Rezoning Transportation Analysis

Petition Number: 2023-107

General Location Identifier: 10505203 & 10505201

Date	Description
10-25-23	First Review (ME)
11-27-23	Second Review (ME)
01-03-24	Third Review (TM)

# RZ-1.0

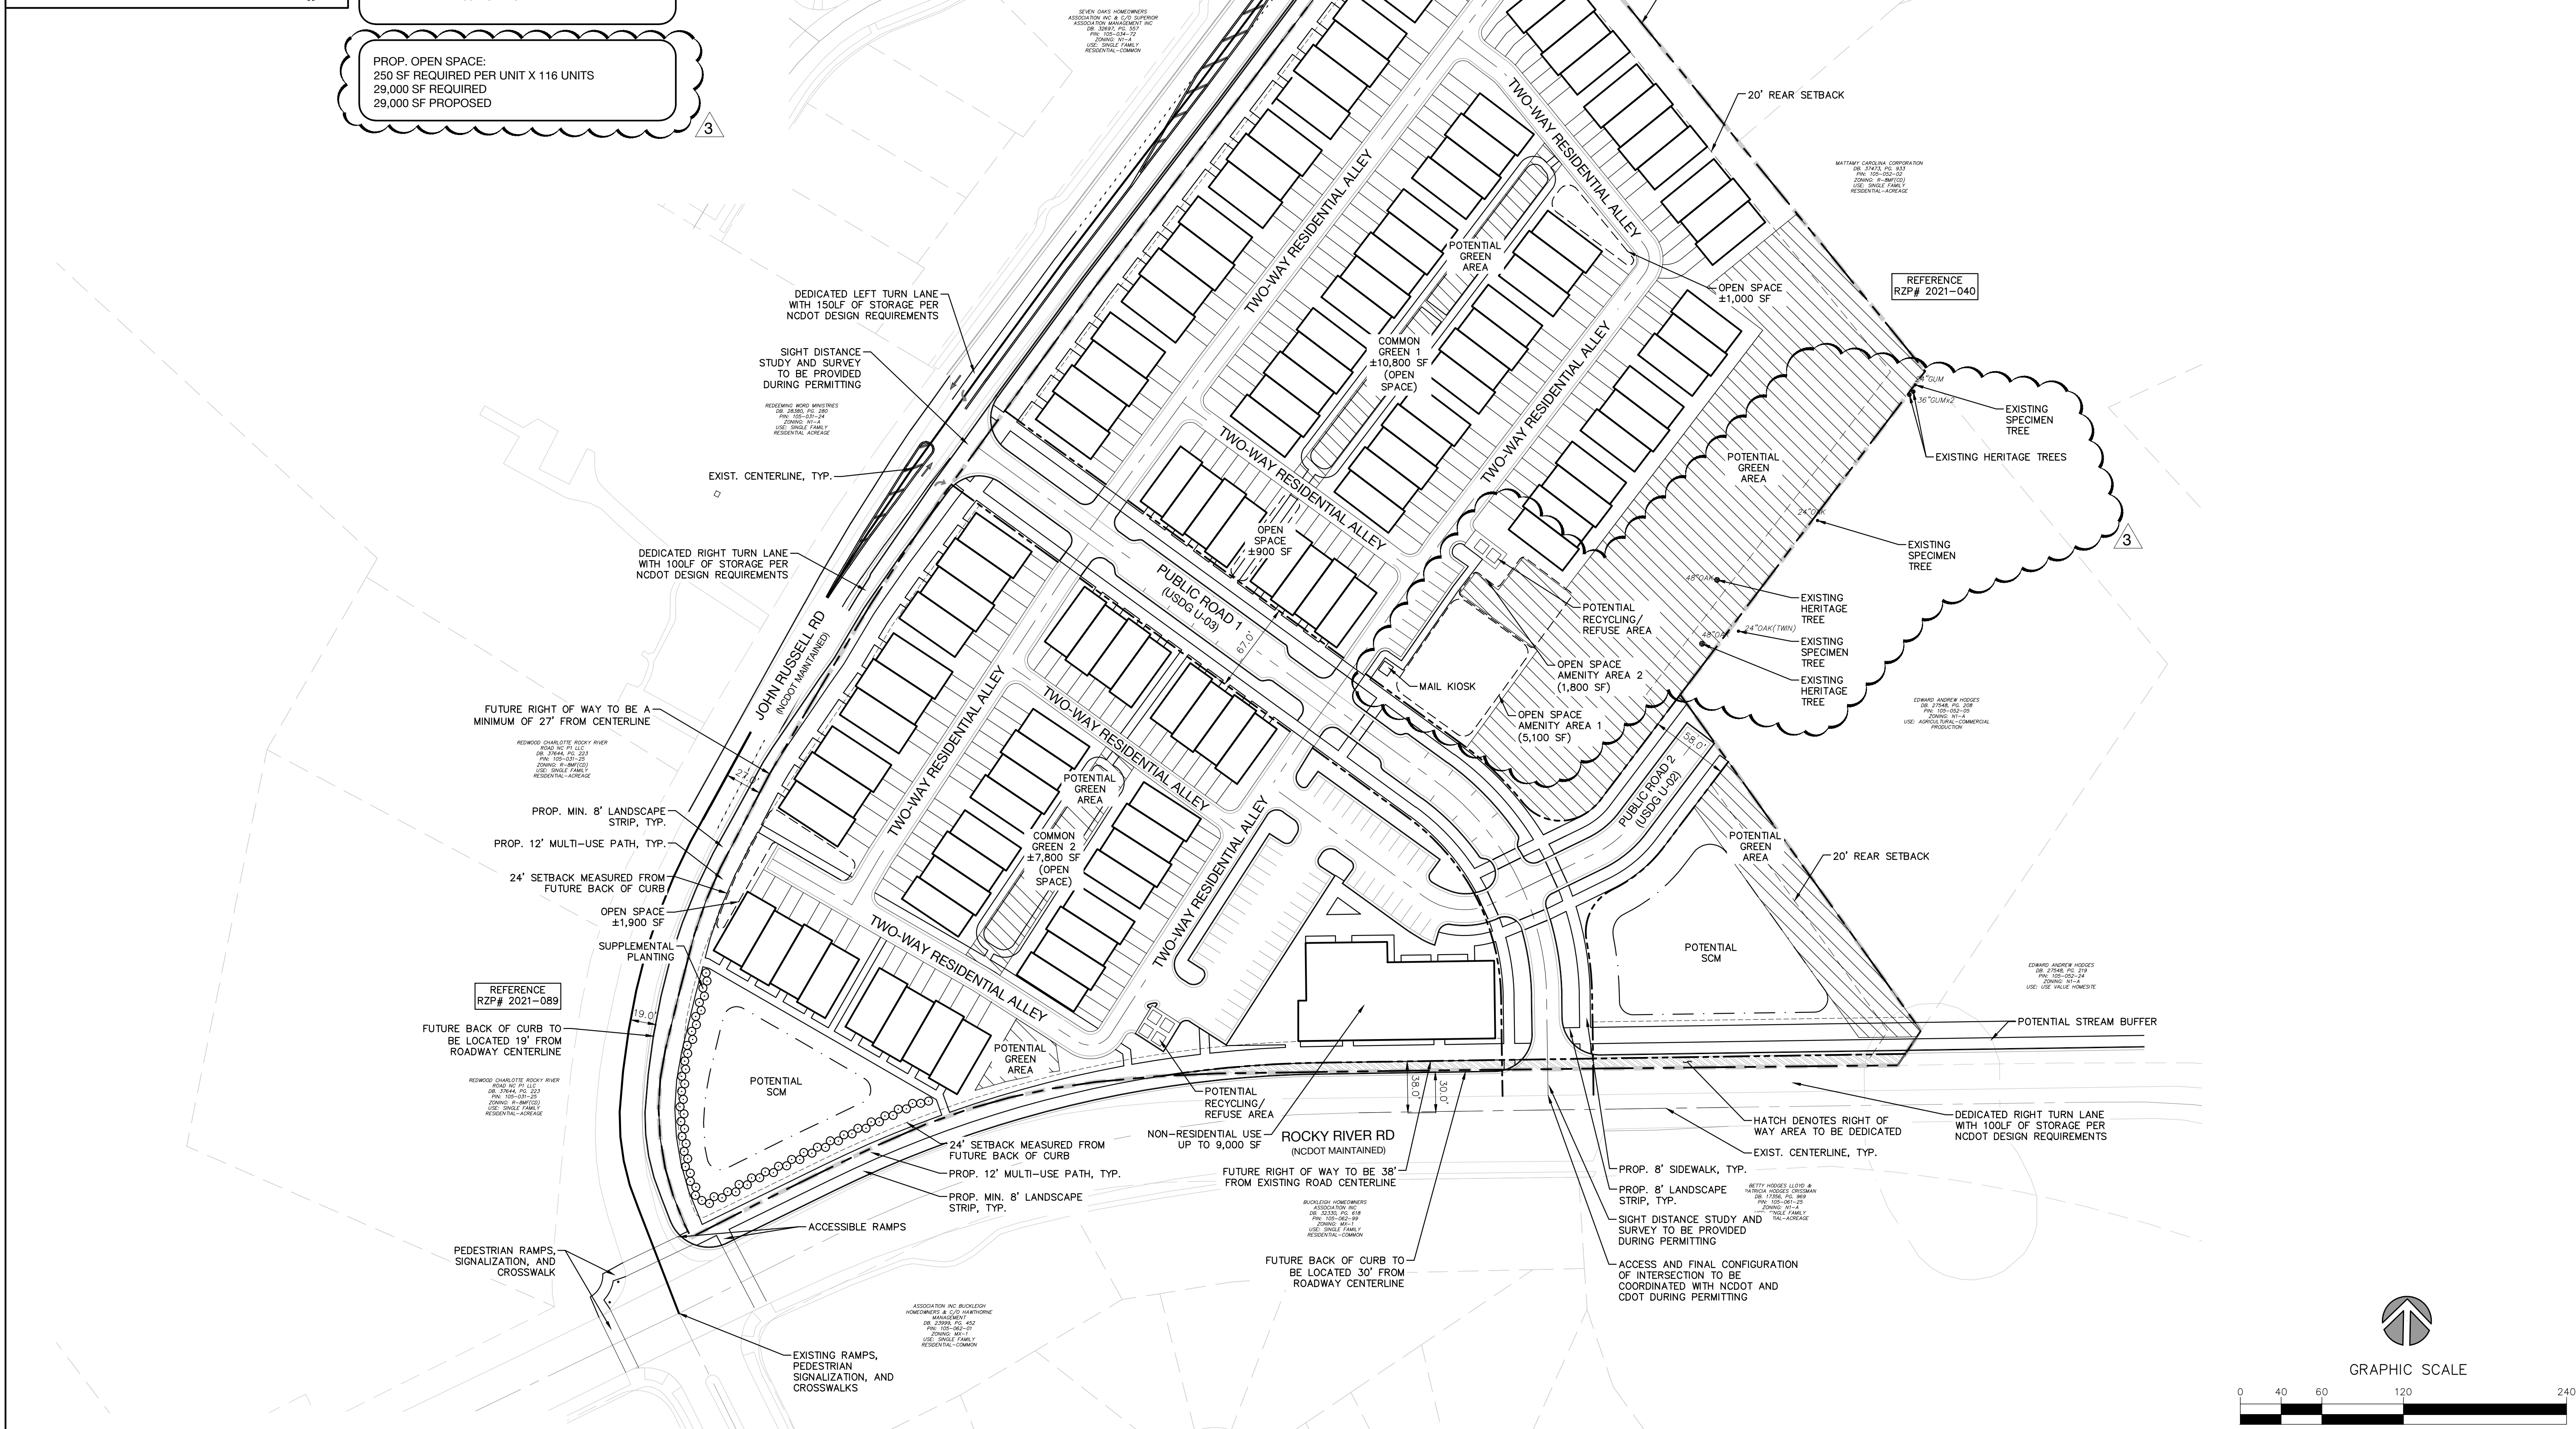
1. Curblines:

- a. ~~Rocky River Road: Location of curb and gutter to be installed to 30 feet from roadway centerline to accommodate the Charlotte Streets Map with a roadway typical section of a 4 lanes or more arterial.~~
- b. ~~John Russell Road: Location of curb and gutter to be installed to 19 feet from roadway centerline to accommodate the Charlotte Streets Map with a roadway typical section of a 3 lanes or less arterial.~~

~~Label and dimension the curb and gutter from the centerline for each road on the site plan.~~

~~**Comment 11-27-23: Please label and dimension the curb and gutter from the centerline for each road on the site plan.**~~

- ~~3. Revise site plan and conditional note(s) to commit to dedicate 38 ft right-of-way from the road centerline for Rocky River Road and 27 ft for John Russell Road. The site plan shall label and dimension the right-of-way from the road centerline.~~

~~**Comment 11-27-23:** Please revise site plan to show correct dedicated right of way for each road with proper labeling and dimensioning.~~

- ~~4. Revise site plan and conditional note(s) to commit to construct an 8-foot planting strip, and 12 foot shared use path on Rocky River Road per Charlotte Streets Map. The site plan shall label and dimension both items from the back of curb and gutter or edge of pavement.~~

- ~~5. Revise site plan and conditional note(s) to commit to construct an 8-foot planting strip, and 12 foot shared use path on John Russell Road per Charlotte Streets Map. The site plan shall label and dimension both items from the back of curb and gutter or edge of pavement.~~

- ~~7. Revise site plan and conditional note(s) to commit to installing ramps, crosswalks, and pedestrian signalization at intersection of Rocky River Road and John Russell Road in coordination with CDOT and NCDOT.~~

~~**Comment 11-27-23:** Please revise conditional note and site plan to show that this will be done for the entire intersection and not just the northeast corner of the intersection.~~

- ~~9. Revise site plan and conditional note(s) to commit to making the access right in and right out access only on Rocky River Road, constructing a dedicated right turn lane into the site with 100 feet of storage and installing a 4 foot concrete monolithic island on Rocky River Road in coordination with NCDOT.~~

~~**Comment 11-27-23:** Please revise site plan and conditional notes to commit to the access and roadway improvements mentioned above from NCDOT. Please add labeling on site plan to reflect this access type.~~

- ~~10. Revise site plan and conditional note(s) to commit to making the access full movement on John Russell Road, constructing left and right turn lanes into the site on John Russell Road with 150 feet of storage and the appropriate tapers, and constructing a three lane road section if proposed right turn and existing right turn lane taper onto Rocky River Road are within 100 feet of each other in coordination with NCDOT.~~

~~**Comment 11-27-23:** Please revise site plan and conditional notes to commit to the access and roadway improvements mentioned above from NCDOT. Please add labeling on site plan to reflect this access type.~~
